**From:** planning  
**Subject:** FW: app3/2017/0569 3 Bailey Green Cottages

**From:** Bloomer, David [<mailto:David.Bloomer@lancashire.gov.uk>]  
**Sent:** 04 July 2017 12:50  
**To:** Victoria Walmsley  
**Cc:** LHS Customer Service; planning  
**Subject:** app3/2017/0569 3 Bailey Green Cottages

SITE PLAN: PROPOSED WOODEN GARAGE AT 3 BAILEY GREEN COTTAGES,  
LONGRIDGE ROAD, HURST GREEN BB7 9QP

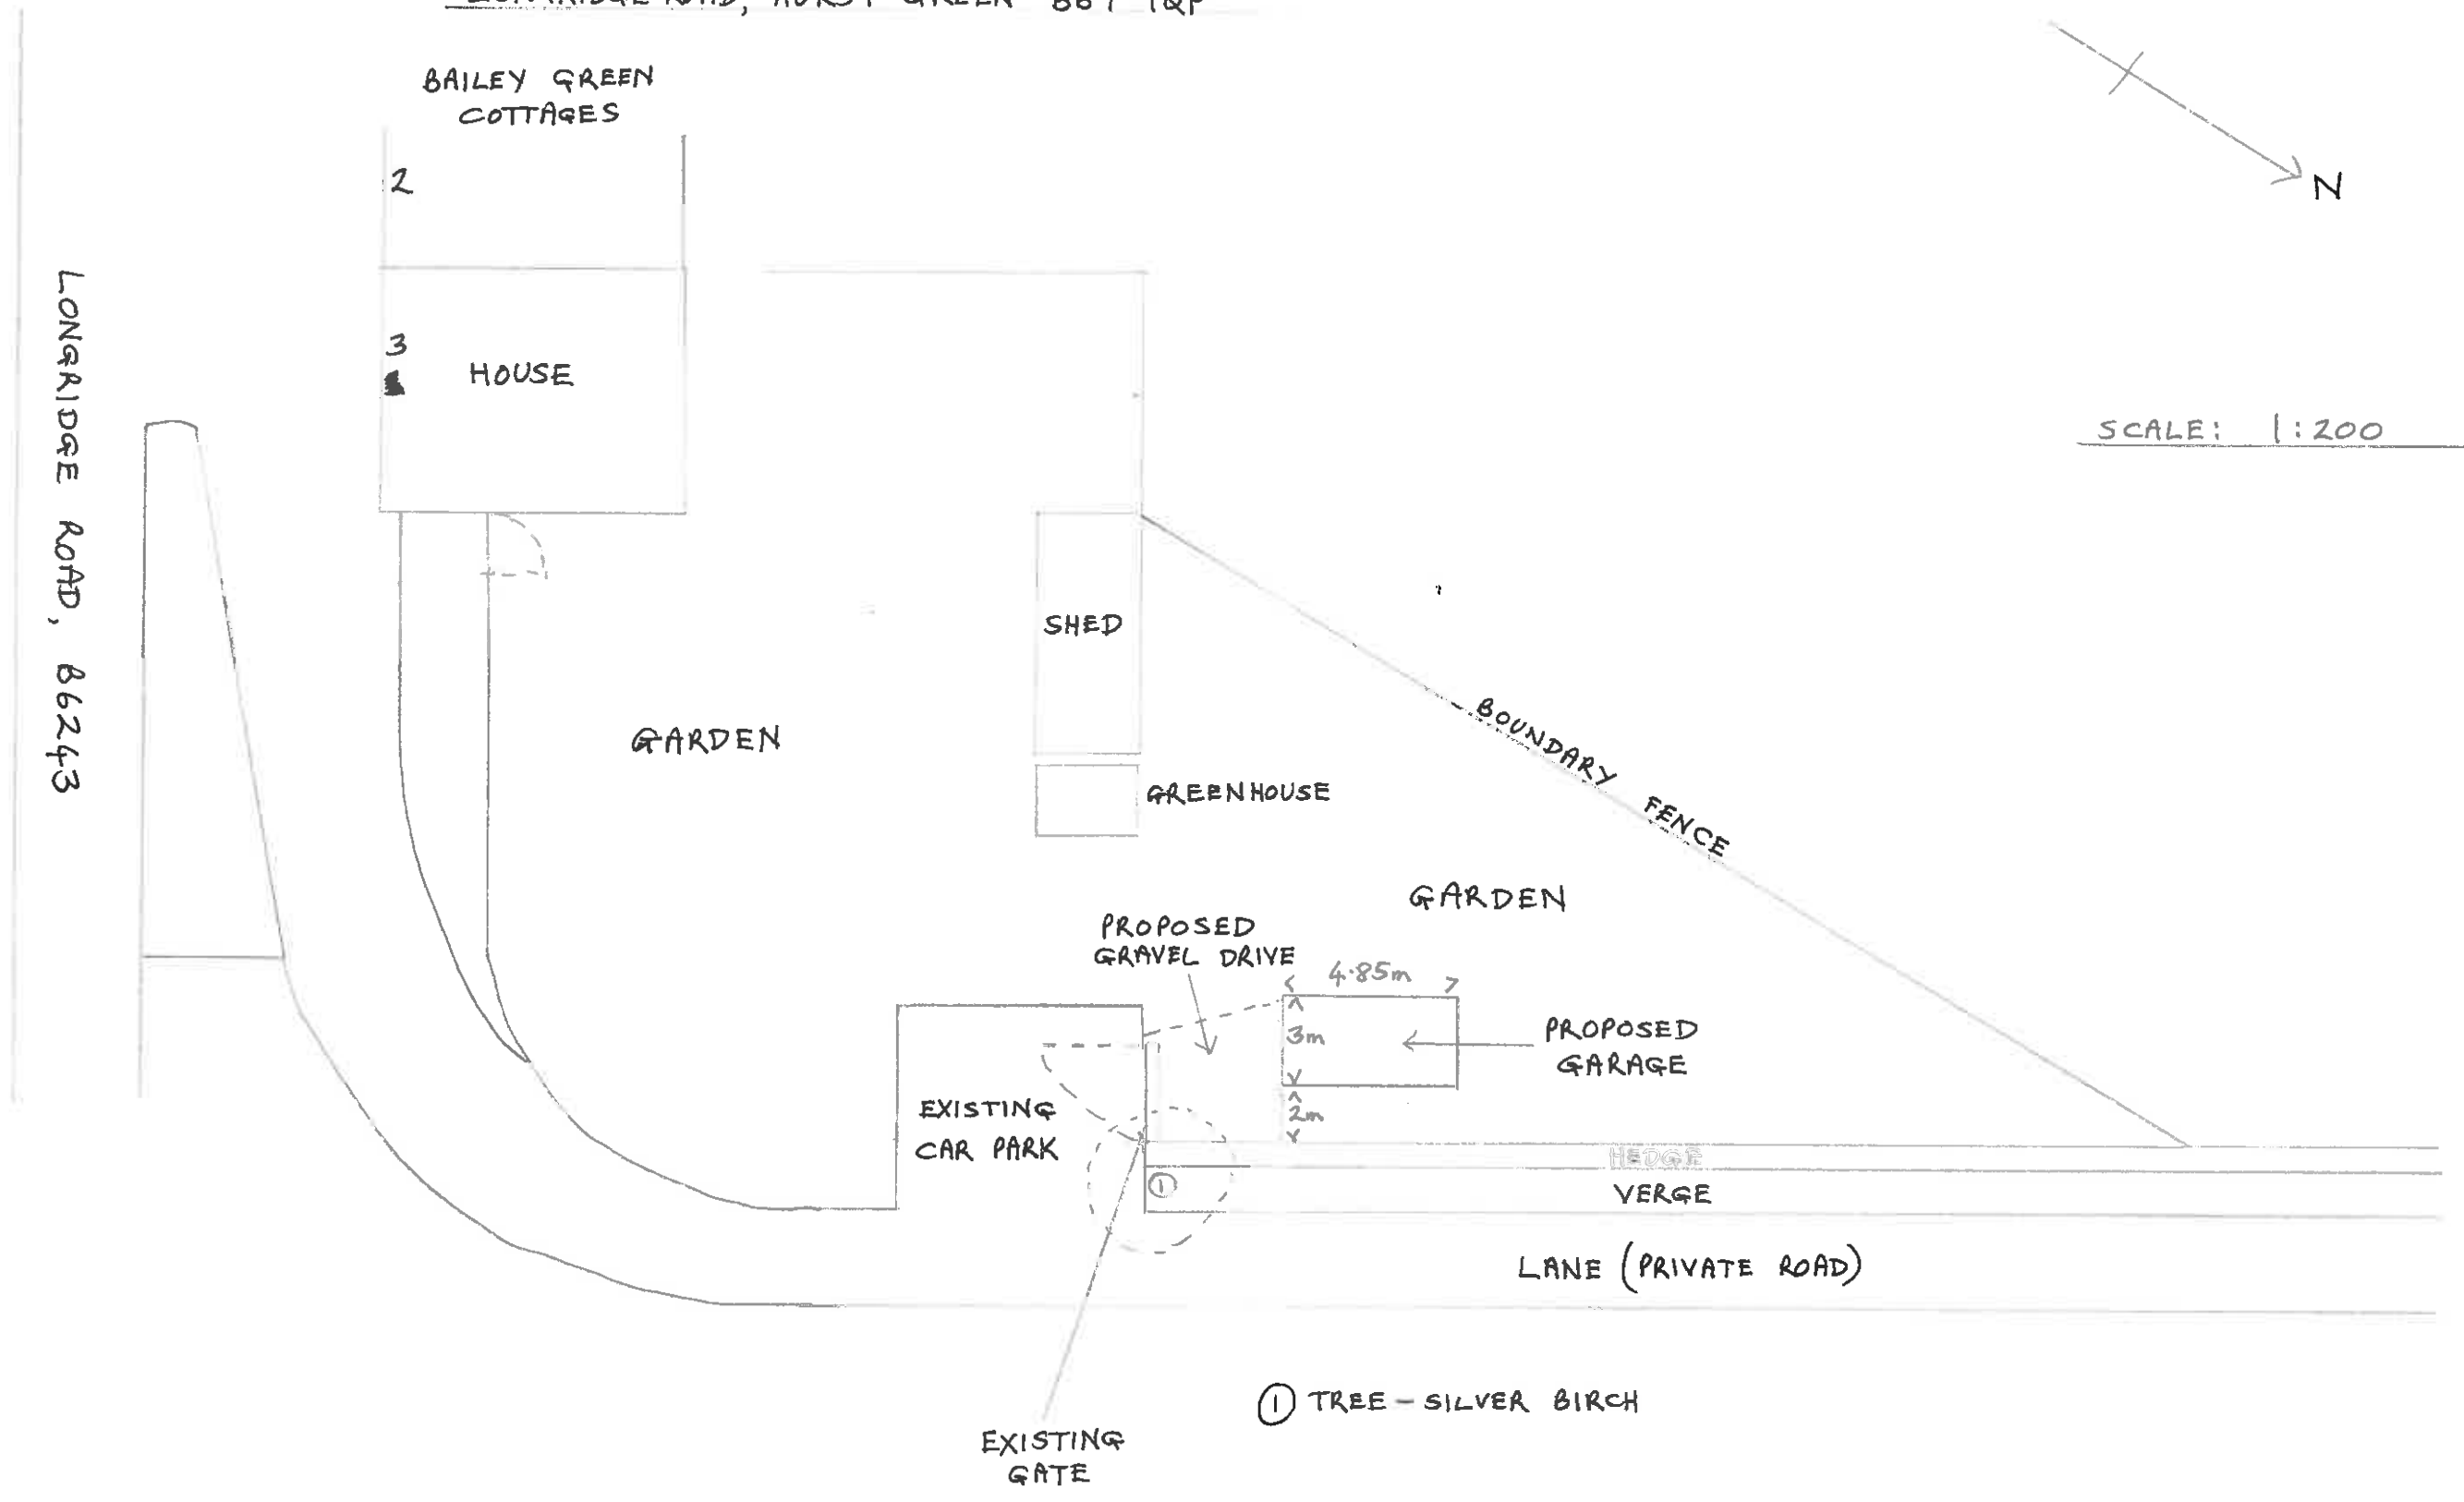
Afternoon Victoria,  
The proposal as submitted raise a number of issues ,  
The garage length is less than the county parking standard of 6m x 3m and consequently its use as a garage may be restricted

The submitted plan shows an existing gate leading to the garage which opens out into the existing parking area. If this was to be retained and access required to the garage on a regular basis then the available parking in the existing parking area would be reduced

Would it be possible to seek clarification on how the garage would be used i.e. garaging or storage and will the existing gate be retained ?
